CITY OF ALBUQUERQUE

December 7, 2015

**RE: Rio Grande Housing – 3010 Rio Grande Blvd
Conceptual Grading Plan and Drainage Report
Engineer's Stamp Date 10-29-2015 (File: G13D030)**

CONCEPTUAL GRADING AND DRAINAGE PLAN

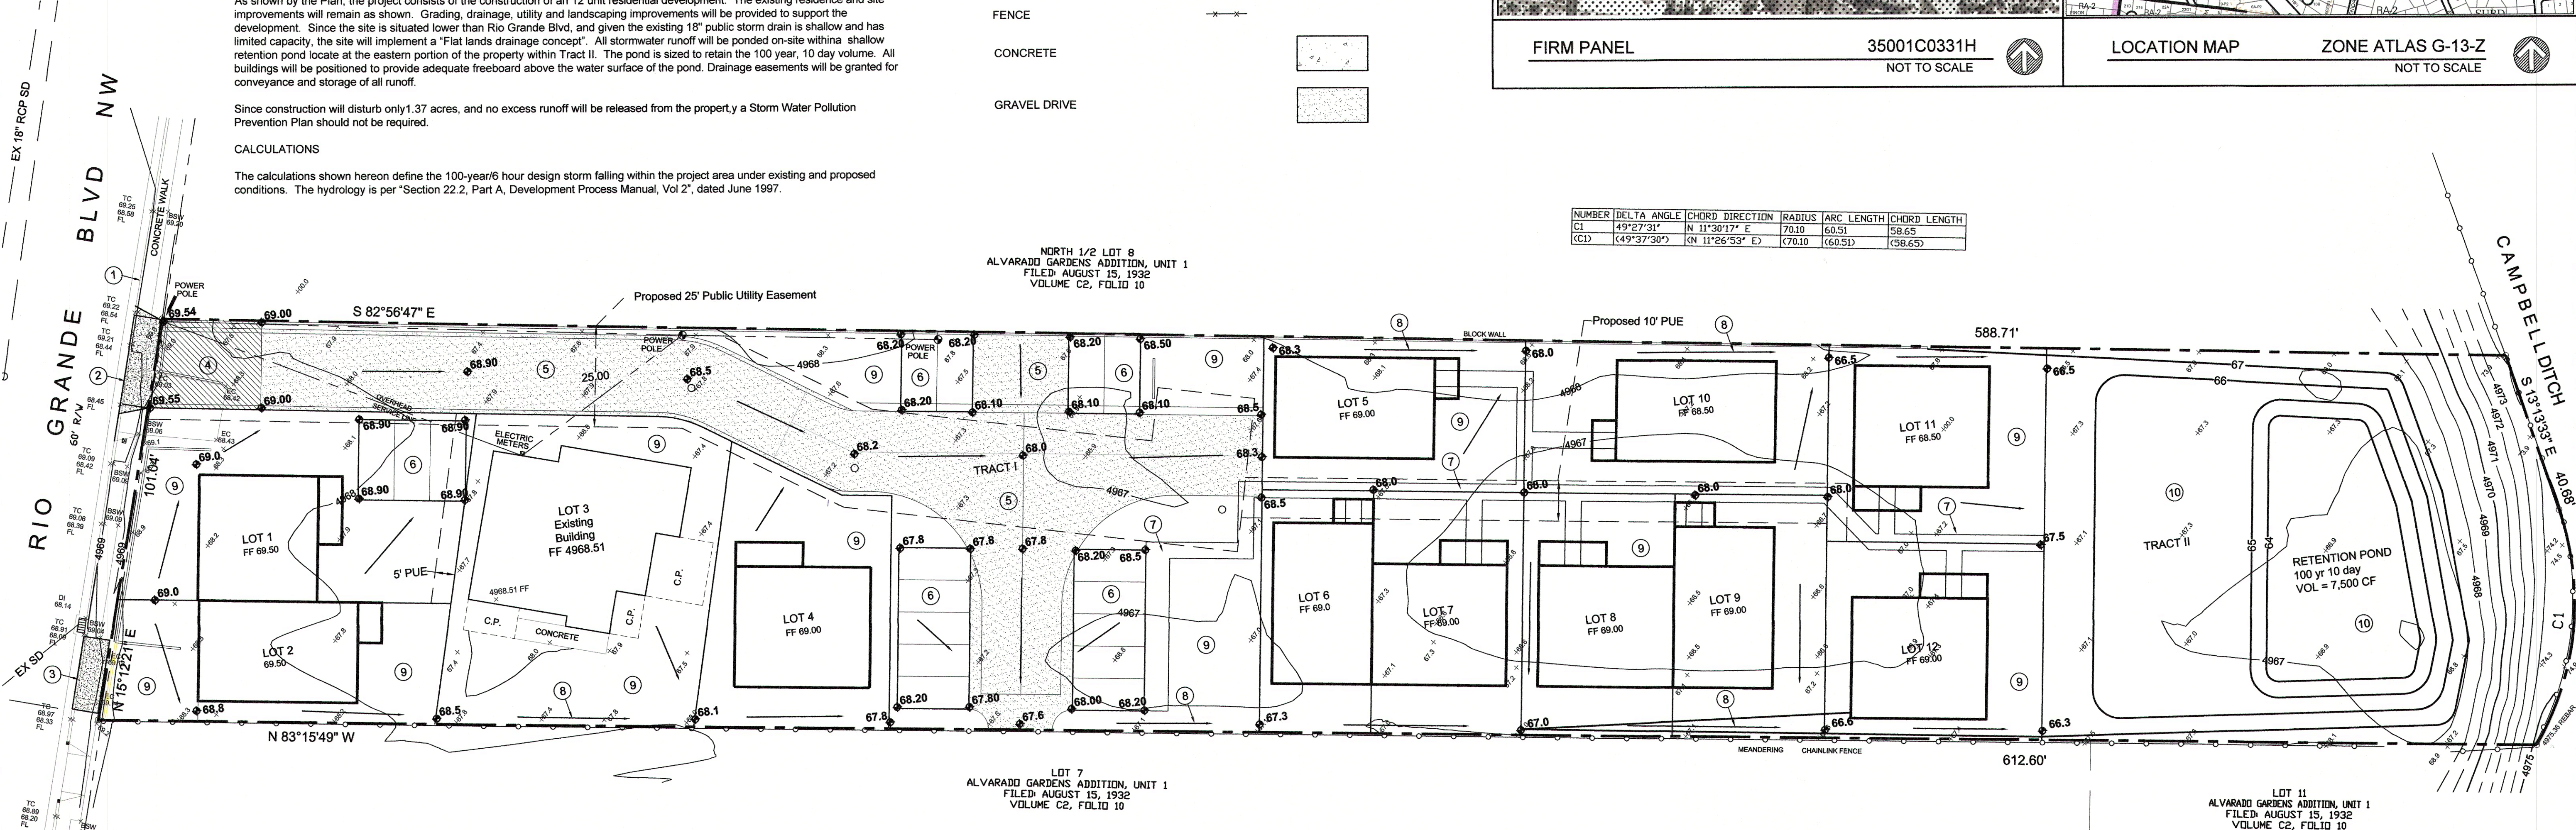
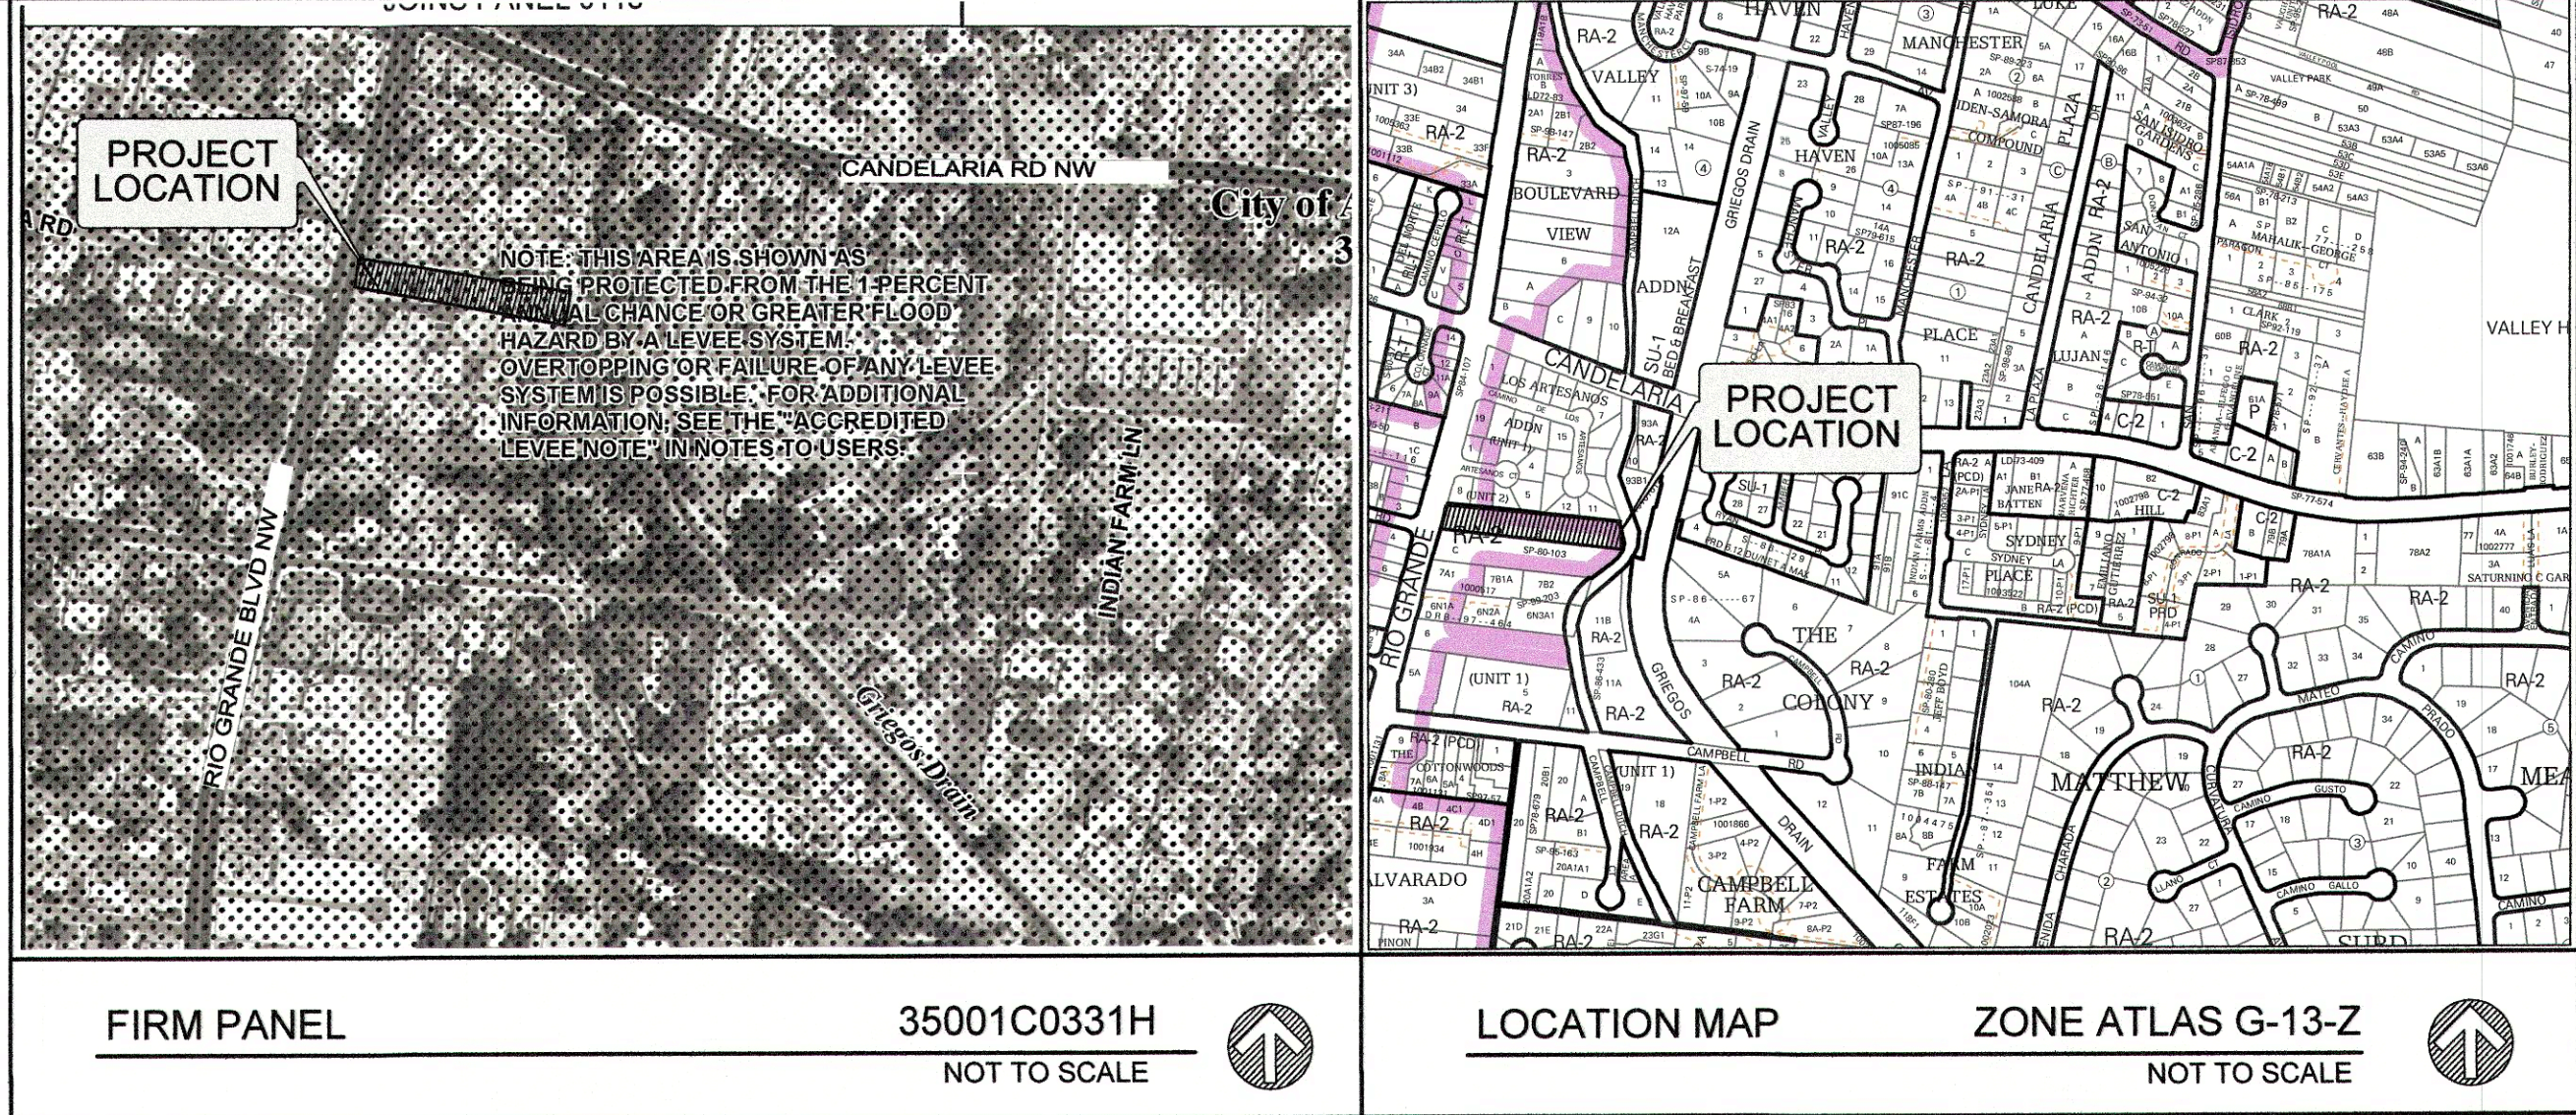
- A Storm Water Pollution Prevention Plan (SWPPP) will be required because the disturbance is larger than 1-acre. The note on the plan (PROPOSED IMPROVEMENTS) needs to be corrected.
- If Lot 3 is to remain undisturbed, it appears that the elevation of Lot 4's SW corner will cause stormwater to spill onto the property to the South.

- It is understood that the existing site is difficult to drain. However, some of the elevations along some flowpaths are shown exactly flat. It appears that nuisance ponding will be an issue if positive drainage is not called for, for example:
 - a. Around the 68.0 EL points that surround Lot 5.
 - b. The parking stall near the NE corner of Lot 4, and the two parking stalls across the lane.
 - c. The flow path along the west side and the carport of Lots 1 and 2.
 - d. Along the back of Lot 3.

Furthermore, we recommend utilizing landscaped areas to manage nuisance ponding where practicable. The average slope across the site appears to be close to 0.5%, which is typically difficult to achieve with asphalt and soft surfaces.
